## WEST SUSSEX COUNTY COUNCIL CONSULTATION

| <b>LOCATION:</b>                | Rear of Inglenook Hotel<br>253-255<br>Pagham Road<br>Pagham<br>PO21 3QB                                                                                                                                                                                                                   |
| <b>SUBJECT:</b>                 | P/171/21/DOC<br><br>Approval of details reserved by condition imposed under ref W/4001476 (P/58/19/PL) relating to Condition Nos 10 - proposed location of one fire hydrant or stored water supply, 12 - soft & hard landscaping, 14 - materials & finishes and 15 - boundary treatments. |

INGLENOOK PROPOSED FIRE MAIN SKETCH

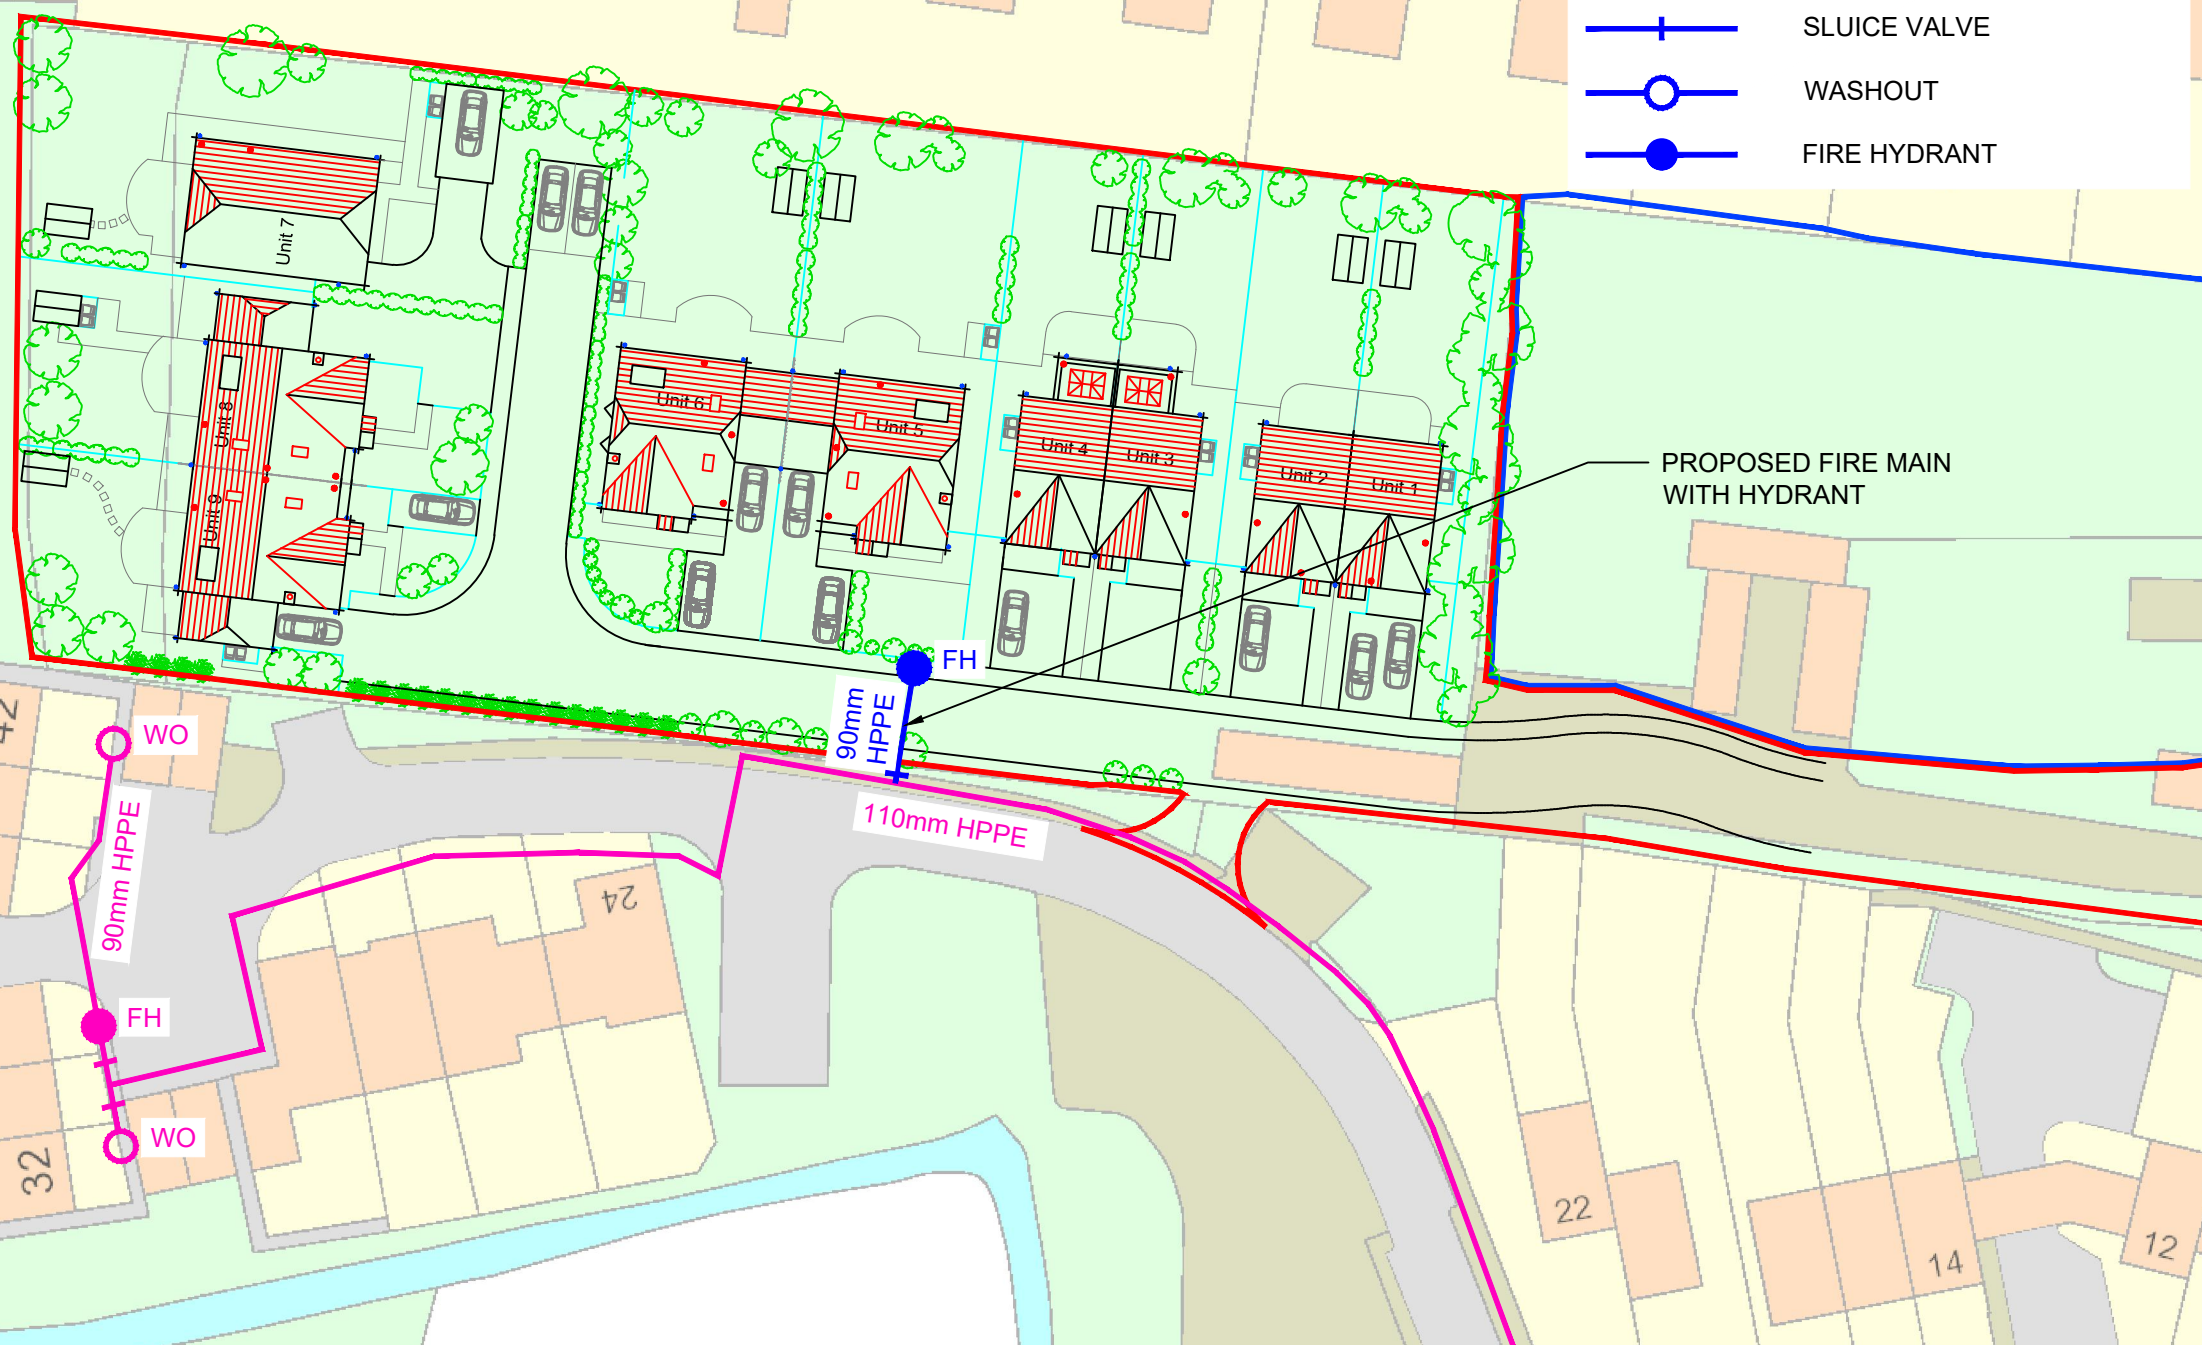
The Fire Access Manager has had several consultations with the developer regarding the supply of water for firefighting and access for a fire appliance. Providing the fire hydrant is provided as indicated on the plan is provided the supply of water will comply with requirements as all properties will be within the required distance. There is a suitable turning facility at the end of the development to enable a fire appliance to turn and make their exit.

On the basis of the above it is considered there is sufficient information to approve the details of Condition 10.
